From: Simon Davis
Sent: 07 July 2017 14:11
To: Karen Parsons
Subject: FW: BR/98/17/PL - Bognor - Fish'n' Chips

Further to the EHO comments relating to odour removal, the cooking equipment installed below the canopy in the cook line is as follows.

DRAWING No.: 2916 MS 01B

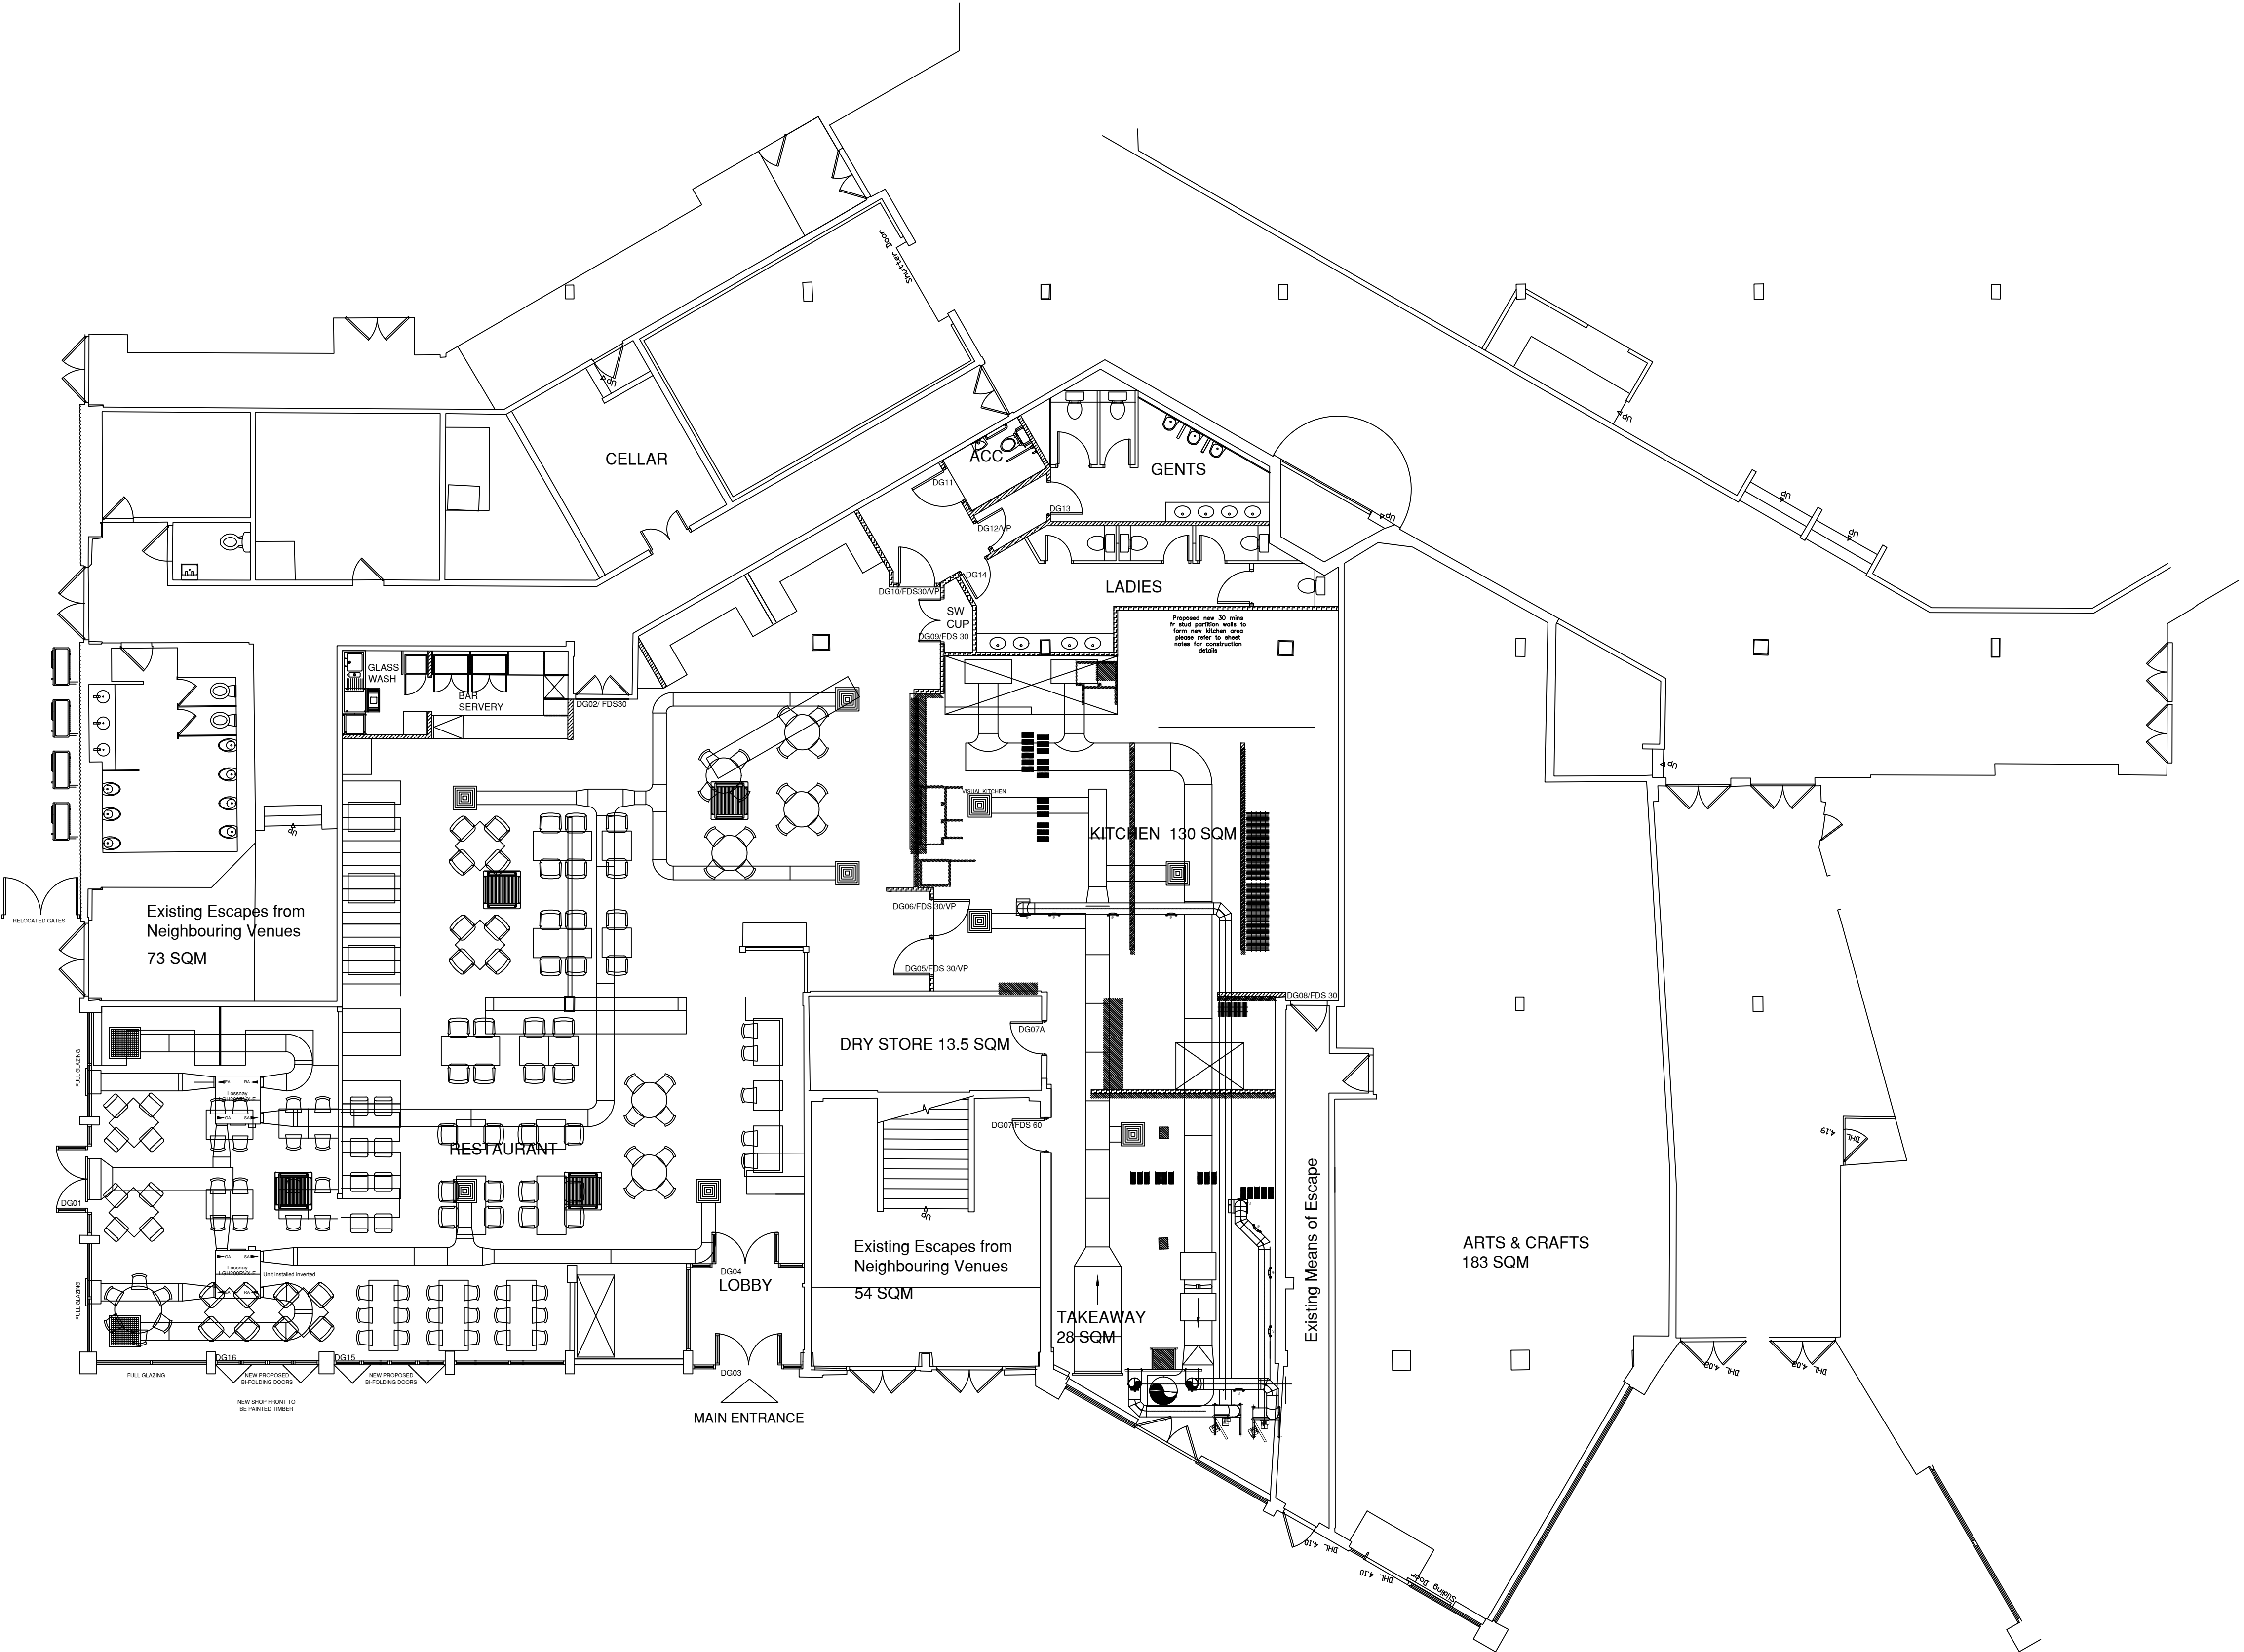
Nick has replied to say that he has reviewed the submitted information again and has consulted the DEFRA guidance which states that such a premises would create high level of grease and odour. He says that on his initial review of the information, he could see that the baffle filters which predominantly are there to remove grease and smoke would, if working and cleaned effectively, reduce the level of grease in the canopy and duct work and hence any odour/gases would be vented through the flue at height above the roof eaves. However, the baffle filters on their own would not be able to address the odour itself. Therefore, he considers that additional controls are required to deal with the odour e.g. pre-filters and carbon, ozone neutraliser, ESP and Ozone etc.

'The kitchen ventilation does not contain odour filtration and so does not have a dwell time for odour catchment. The filters within the kitchen canopy are inclined baffle type to provide grease capture and to prevent flame carryover in to the extract ductwork.

Item 32	Rise and fall grill.
Item 33.	Four zone induction hob and combi oven below.
Item 34	10 grid electric combi oven.
Item 35	Panasonic microwave oven.

Based upon this we have not made any provision for odour removal beyond grease removal. The above detailed equipment should not generate levels of odour in the exhaust to cause any nuisance or to require odour filtration to be installed as part of the canopy installation. Any low levels of odour and steam generated will be dispersed above the eaves level approx. 10 / 12 meters above ground level. This will then not cause any problems to any neighbouring trading units within the site boundary and will therefore cause zero nuisance beyond the site.
